From: Matthew Chadwick
Sent: 09 November 2020 15:32
To: DC Support
Subject: FW: 20/01933/F - Wigginton

From: patrickprendergast@bucksplantcare.co.uk <patrickprendergast@bucksplantcare.co.uk>
Sent: 05 November 2020 12:13
To: Matthew Chadwick <Matthew.Chadwick@Cherwell-DC.gov.uk>
Cc: Jonathan Emanuel <jonathan.emanuel@cherwell-dc.gov.uk>
Subject: RE: 20/01933/F - Wigginton

I am not sure if you are dealing with this one, but we have not had a response back from Arboriculture yet. The application is for a new dwelling in the open countryside, which seeks to get rid of a lot of trees and plant a lot of new ones as well. Would it be possible to get a response on this from yourself or a colleague?

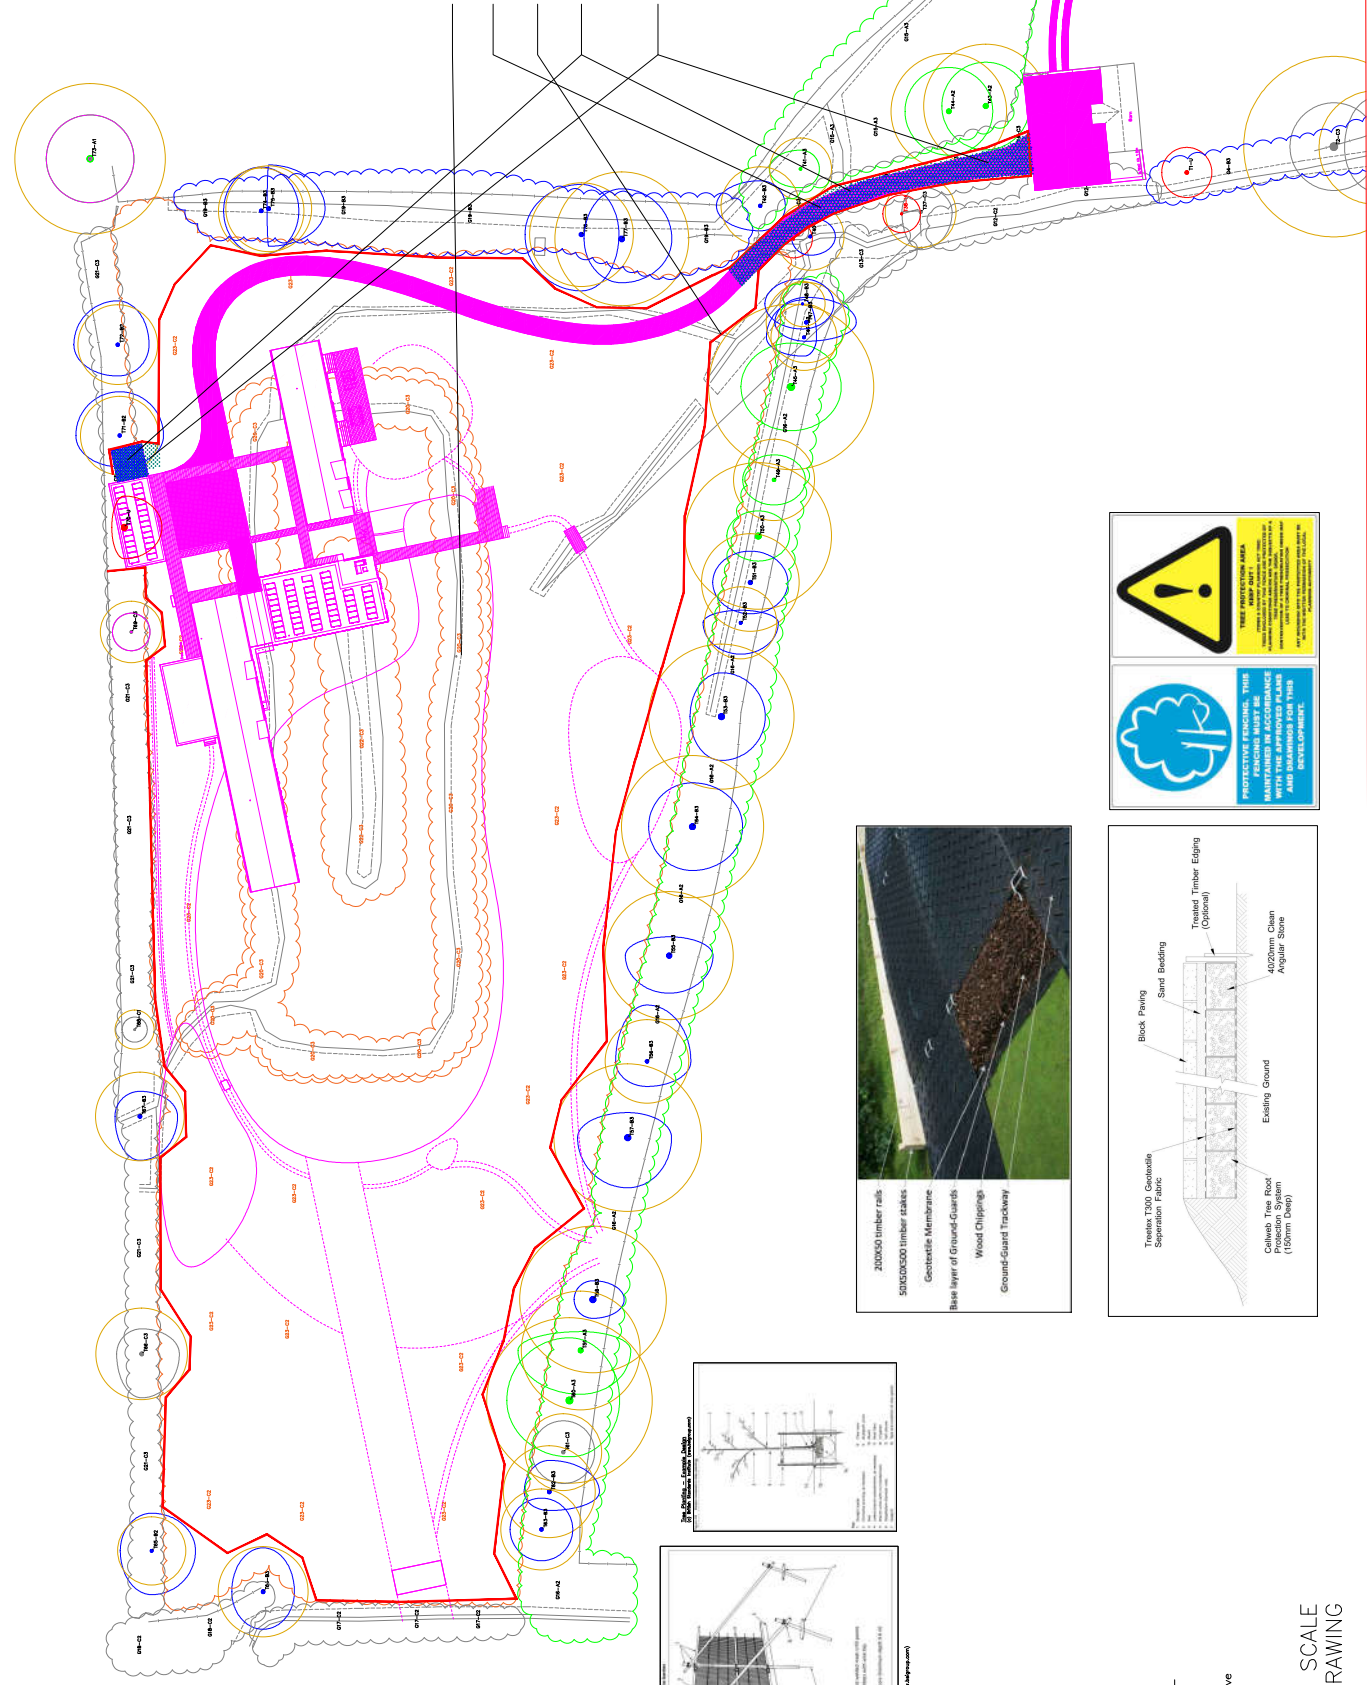
- The proposed removal of groups G20; G22 and G23 are ok as they do not have high amenity value.
- I cannot see any detail on services. I note there are proposals for energy creation on site but will a water supply be required and what route will it take as the entrance is tree lined.
- The Tree Protection plan (TPP) is ok but I suggest protecting the RPA of tree T 71 until the build had been completed. Then install the parking area using no dig methods. The Access statement mentions reinforced grass system, which is not what is specified in the Tree Protection plan.

- Although there is mention about protecting the access drive it states before or after. It must be done before unless there is another access point for construction traffic.
- There is a detail cross section for no dig construction but it does not state that is the specification for the drive and parking area. Also it does not state that the block paving is permeable.

- Also the contractor's compound and facilities have not been defined on the TPP.
- So a detailed Arboricultural method statement along with an updated TPP are required ----- they can be in conditions as do not deter from approving the application ---- to set out
